Add: PCD File No PPR1921

APOSTOLIC CHRISTIAN CHURCH  
1275 Old Ranch Road  
El Paso County, Colorado 80921

# Site Development Plan\_v1-redline.pdf Markup Summary

SHEET 1 OF 1

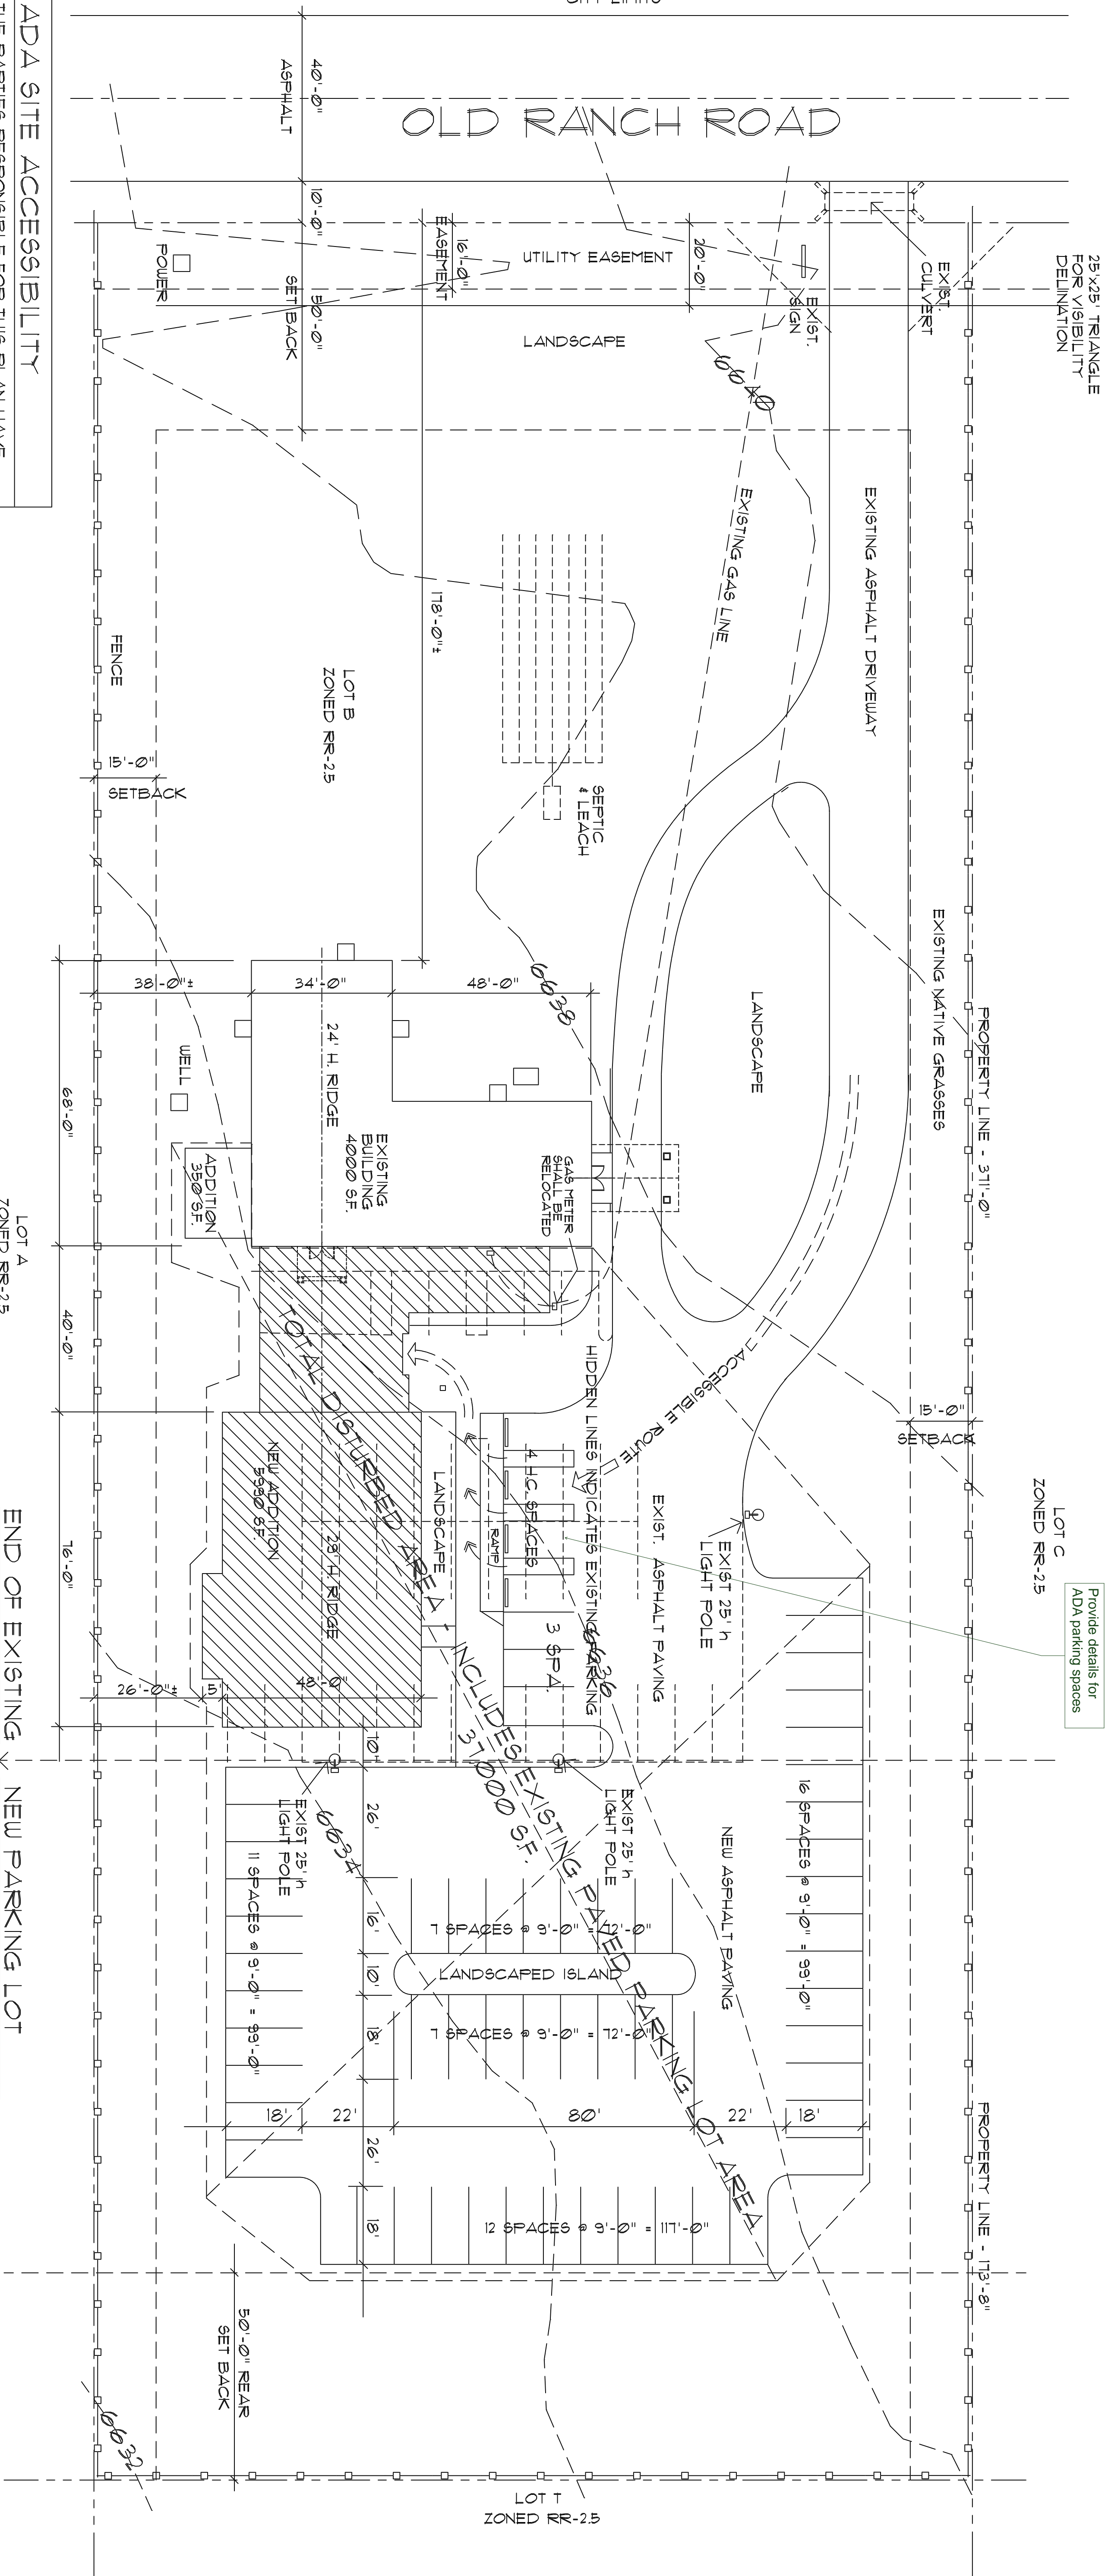
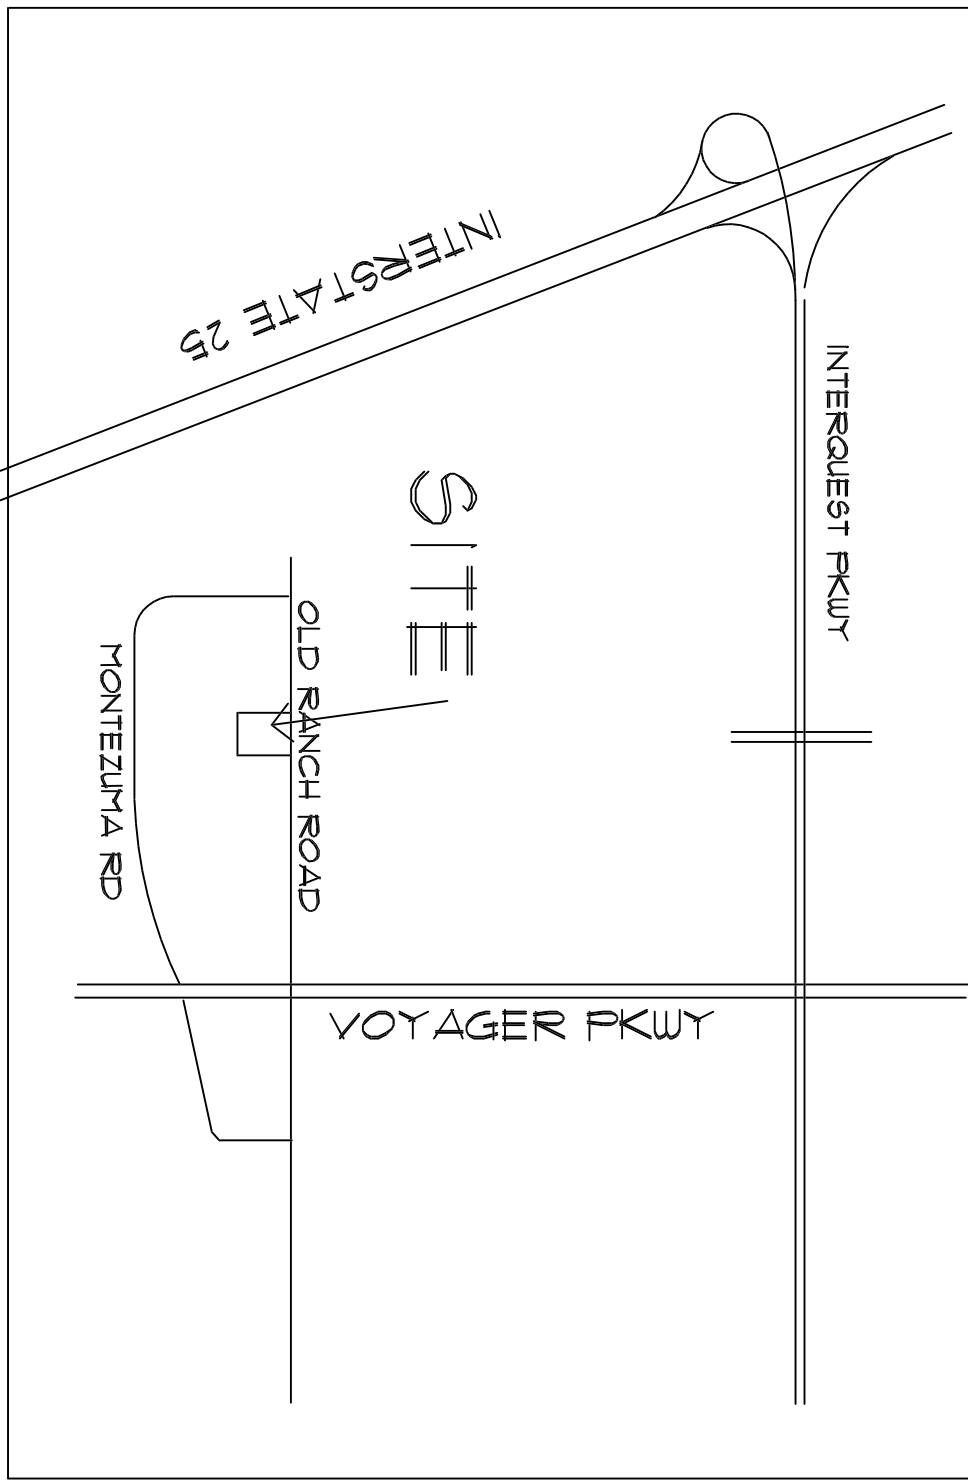
3 ADA spaces are required, additional to the 55 that are required or the seating. 1 parking space for every 4 seats, plus ADA spaces per table 6-3 in Land Development Code.

Include this note:  
The parties responsible for this plan have familiarized themselves with all current accessibility criteria and specifications and the proposed plan reflects all site elements required by the applicable ADA design standards and guidelines as published by the United States Department of Justice. Approval of this plan by El Paso County does not assure compliance with the ADA or any regulations or guidelines enacted or promulgated under or with respect to such laws.

Show existing parking and proposed parking.

Show rear-yard setback line.

This is RR-2.5
